Modification of Minister's Approval

Section 75W of the *Environmental Planning and Assessment Act 1979*

05_0016 was granted by the Minister for Planning on 12 March 2008 and subsequently modified under delegated authority by the Director, Metropolitan and Regional Projects North on 25 February 2013 (MOD 1 to Concept Plan).

- Update of title references;
- Update of plan references to reflect new staging;
- An increase from 3 to 17 stages;
- Change to Precinct references;
- Change to allow construction certificates to be released for more than one stage at a time;
- Change to allow a registered surveyor to provide certain drainage plans;
- Delete duplicated condition relating to water and sewer infrastructure (B11);
- Changes to the timing and location of the informal park (B20) and consolidation into one central park in Precinct B;
- Include identification of development parcels in Precinct C;
- Changes to design measures to prevent vehicles entering adjoining conservation area;
- Remove restriction on land which will be dedicated as a public reserve;
- Changes to timing of the pedestrian and cycle paths in Precinct C; and
- Withdraw commitments that are addressed in approval con

INDICATIVE LOT LAYOUT FOR PRECINCT B SUBDIVISION
DOLPHIN POINT CITY OF SHOALHAVEN

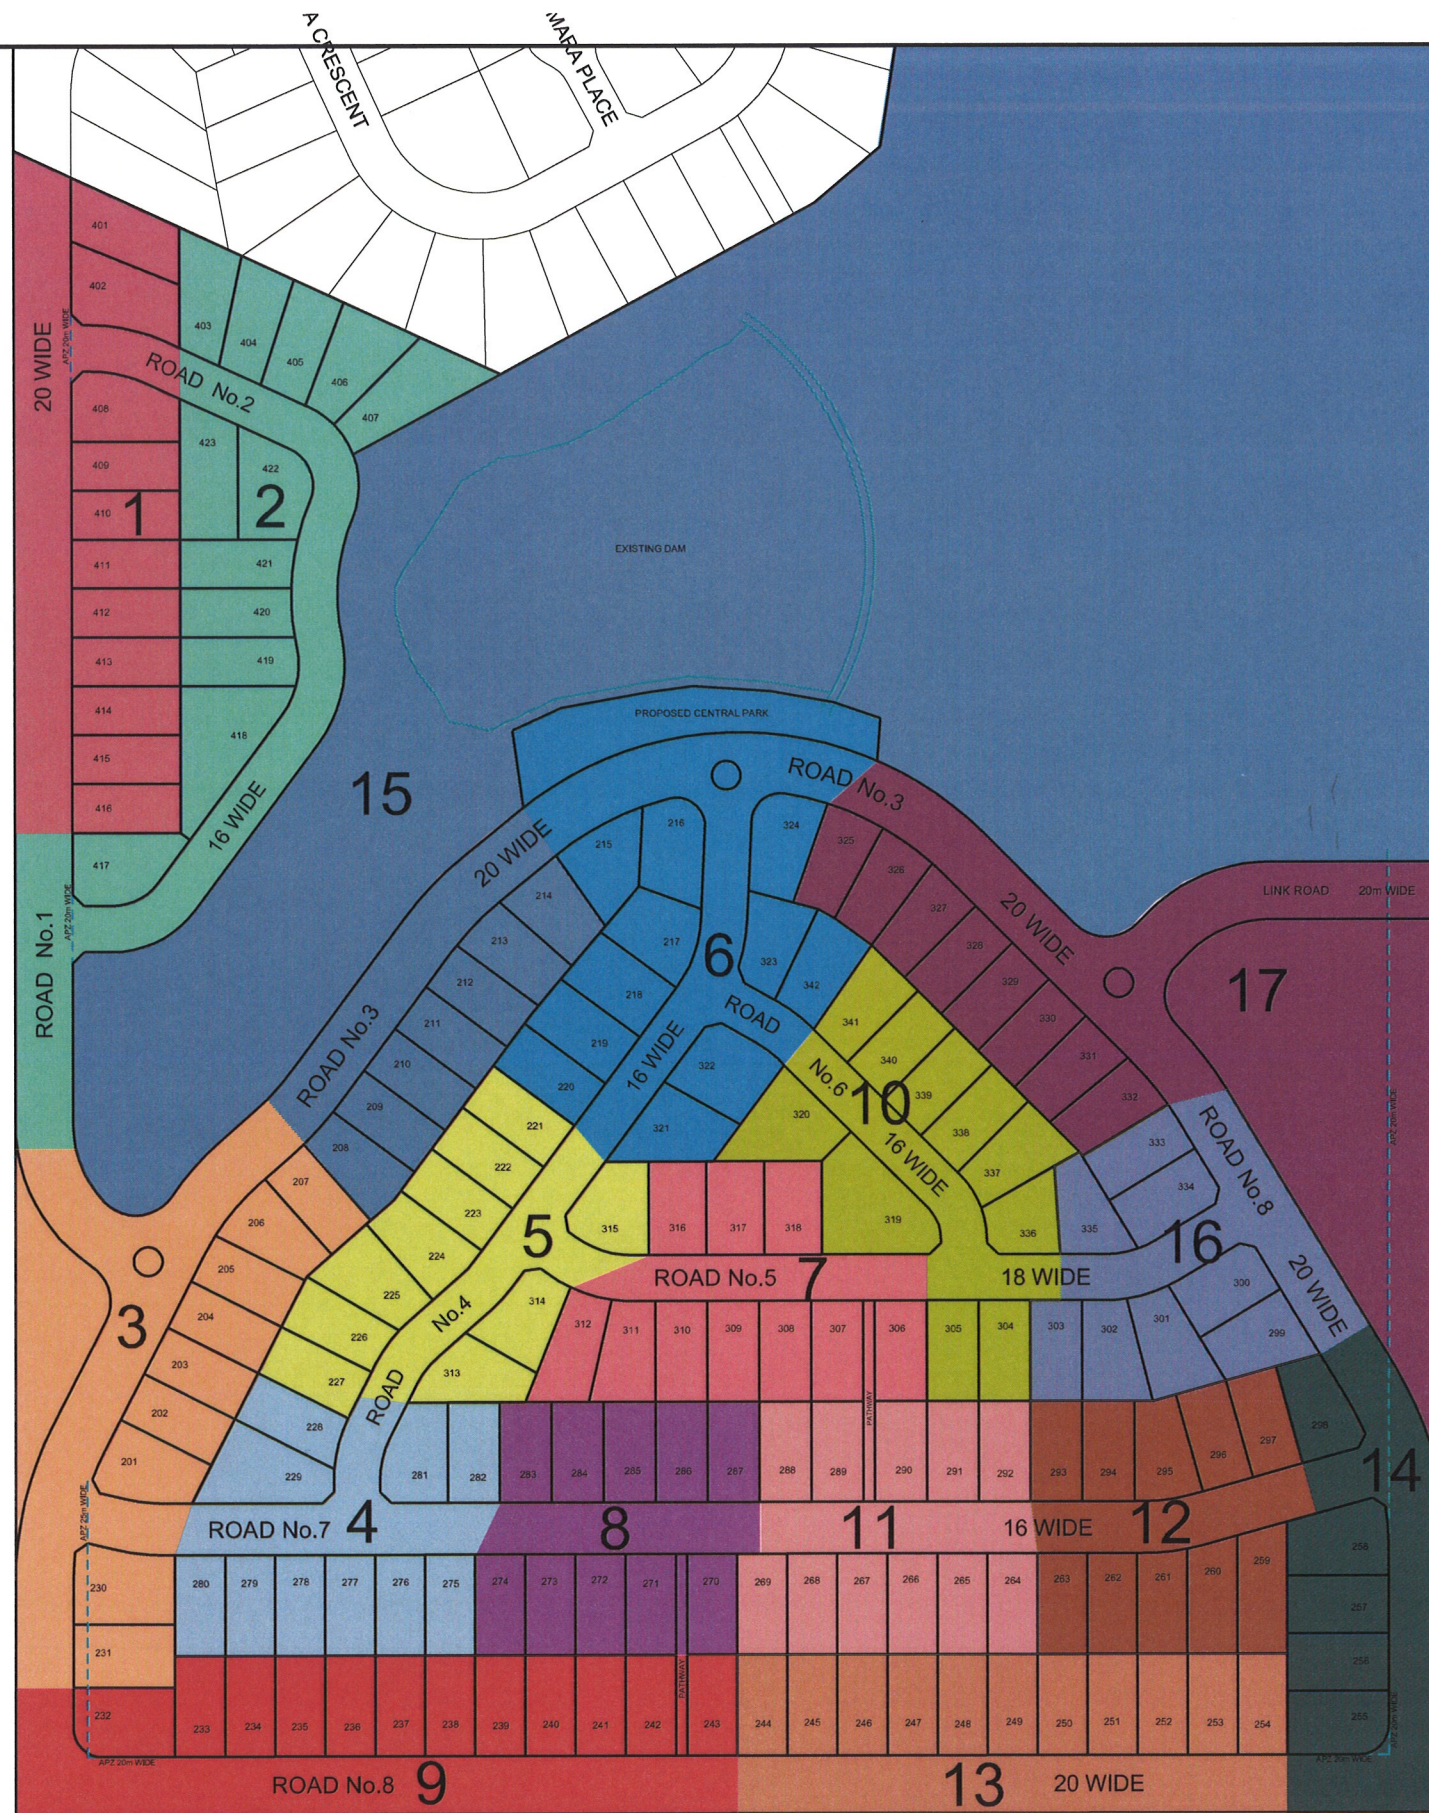
- (1) A central park is to be provided between the dam and Road 3 as shown on the Plan prepared by Rygate and West Issue D dated 13 November 2013 ("proposed central park") in Stage 6 Precinct B of the subdivision. The design of the central park shall incorporate the following:-

- a generally grassed area of a minimum of 1500m² with scattered trees (with one grassed area of suitable size for informal ball sports);
 - embellished with a minimum of 4 x picnic table and chair sets under shelter, 2 x electric operated BBQs in accordance with Council's design, 1 x bubbler and 2 x rubbish bins (no toilets required);

- an accessible path of travel between the road, picnic tables, and BBQs; and
 - separated from the dam by a childproof fence that satisfies the Australian Standard for swimming pool fencing.

PLAN SHOWING CONCEPTUAL STAGING
FOR SUBDIVISION OF PRECINCTS A & B
DOLPHIN POINT CITY OF SHOALHAVEN

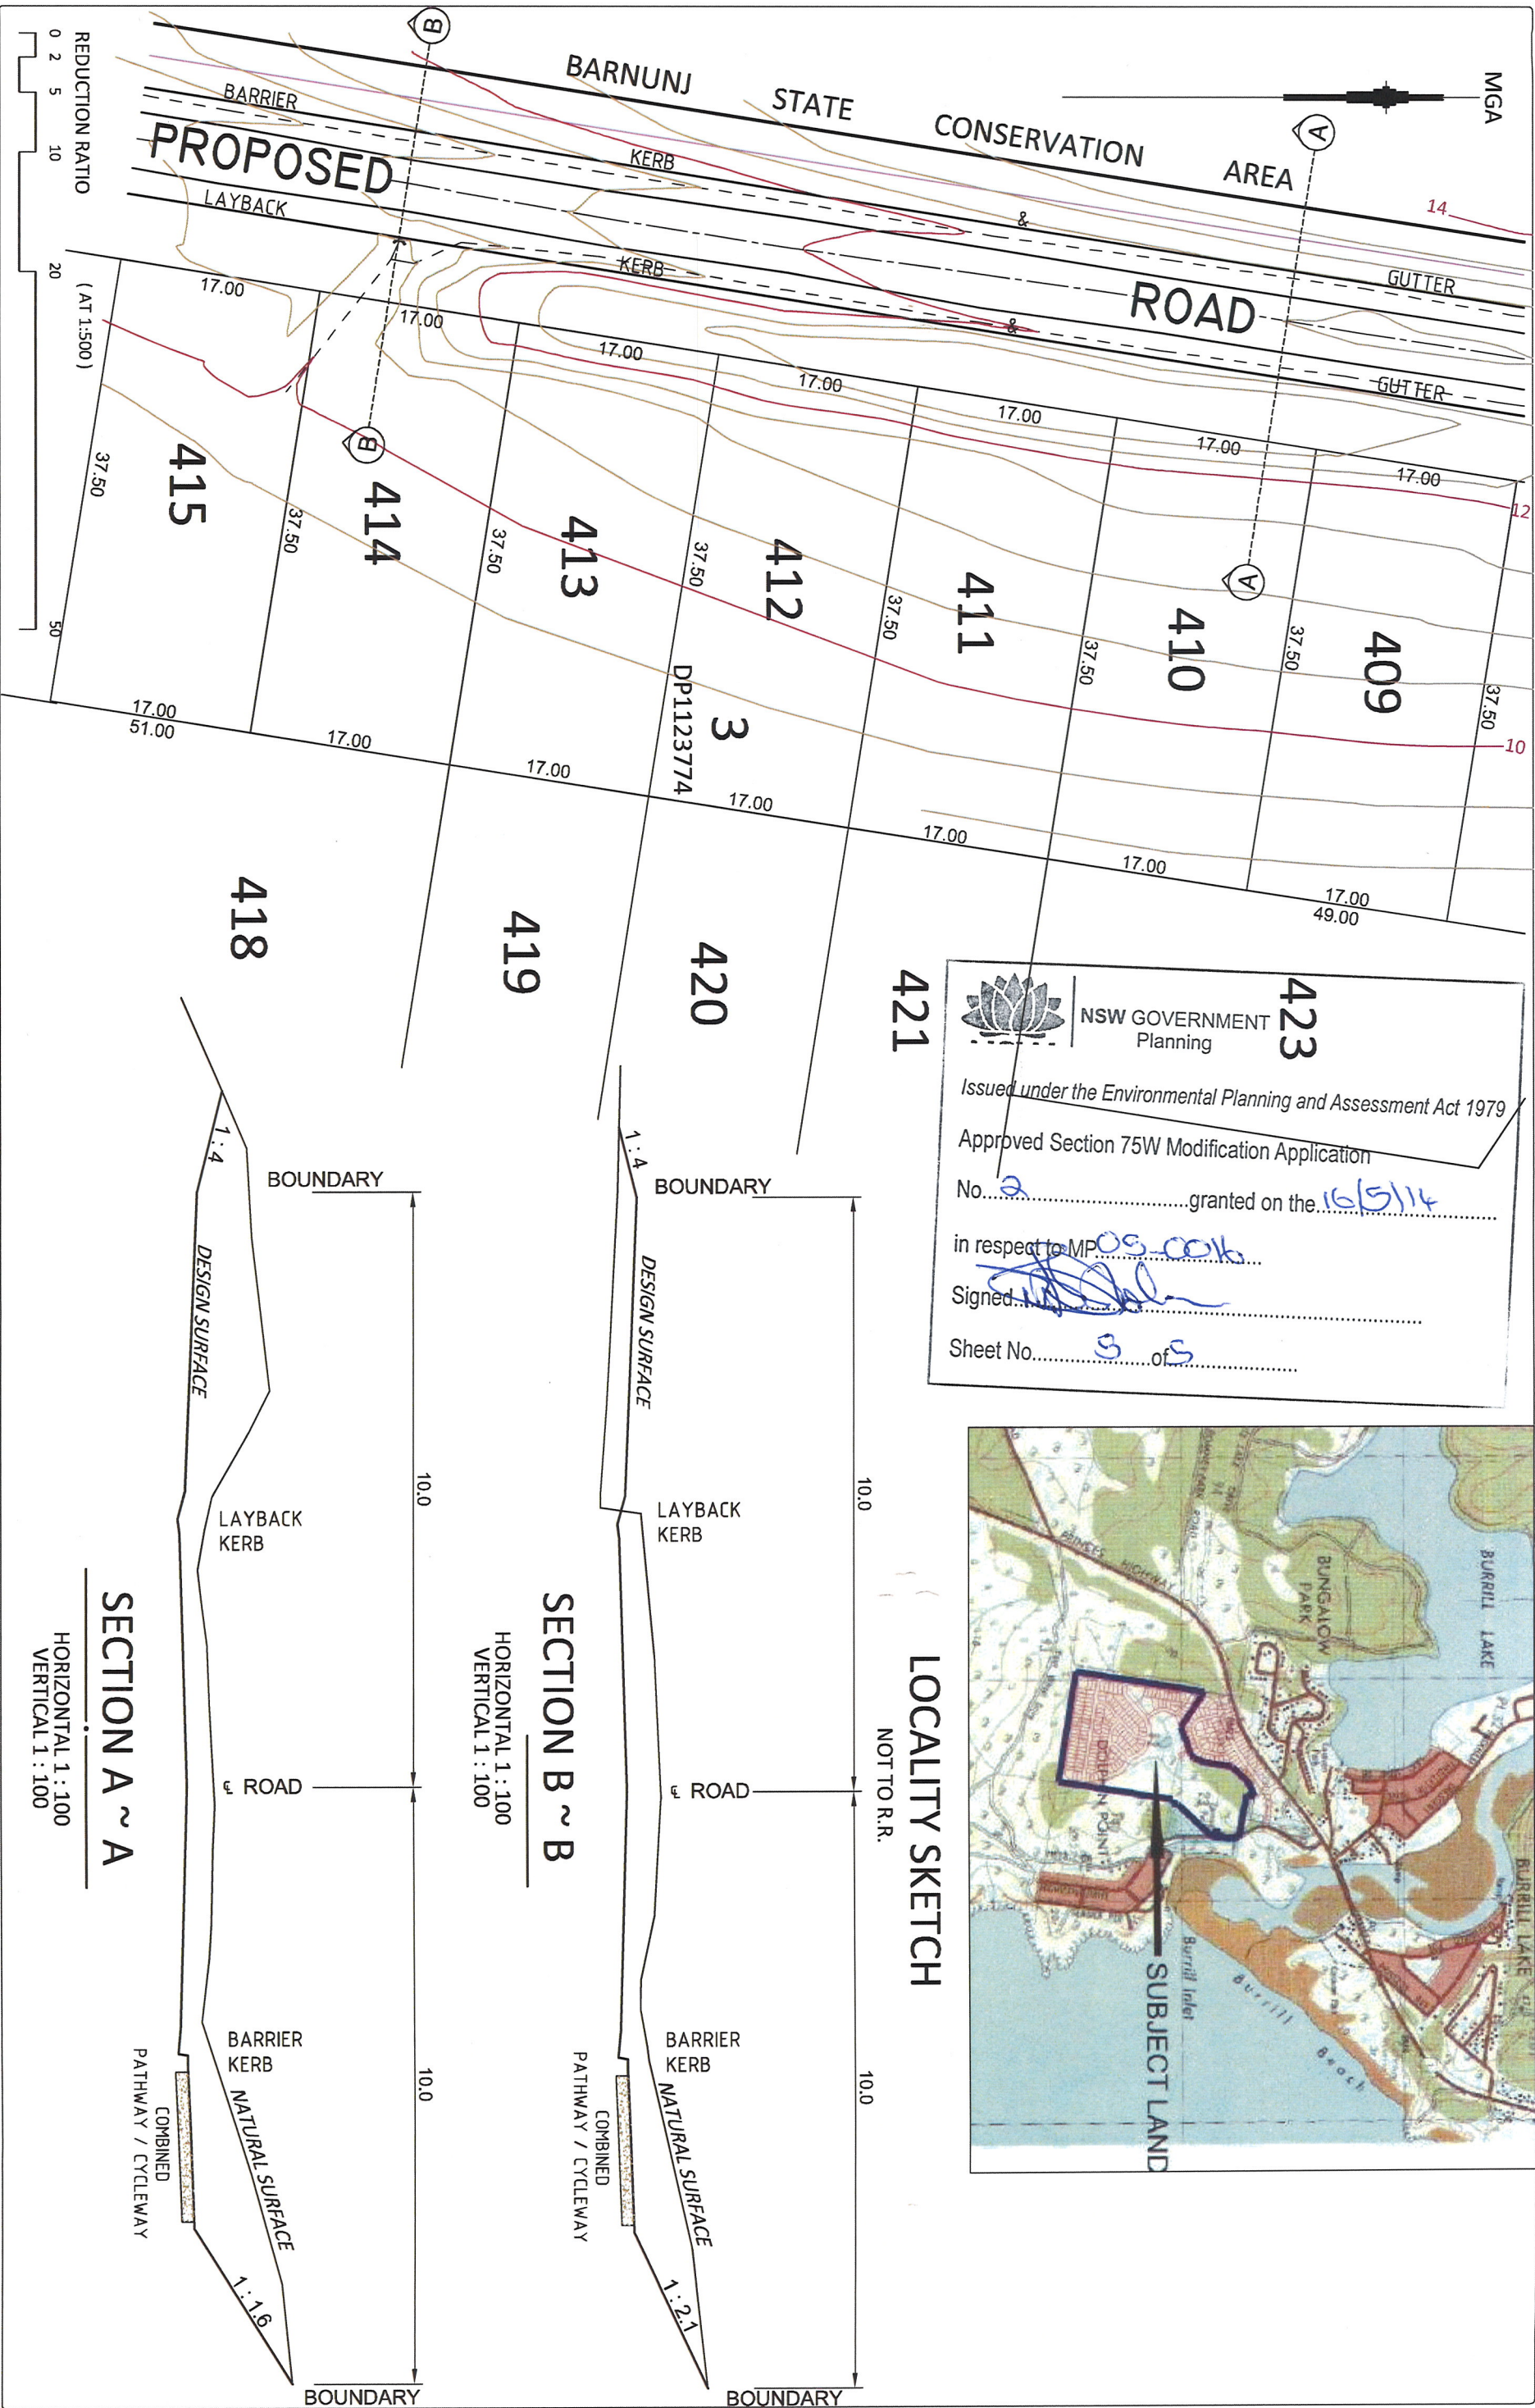
The subdivision development shall be carried out generally in accordance with the approved staging plans, in numerical order, referred to in the Conceptual Staging Plan prepared by Rygate and West, Drawing No U11840M Sheet 4 of 4, Revision D dated 13 November 2013.
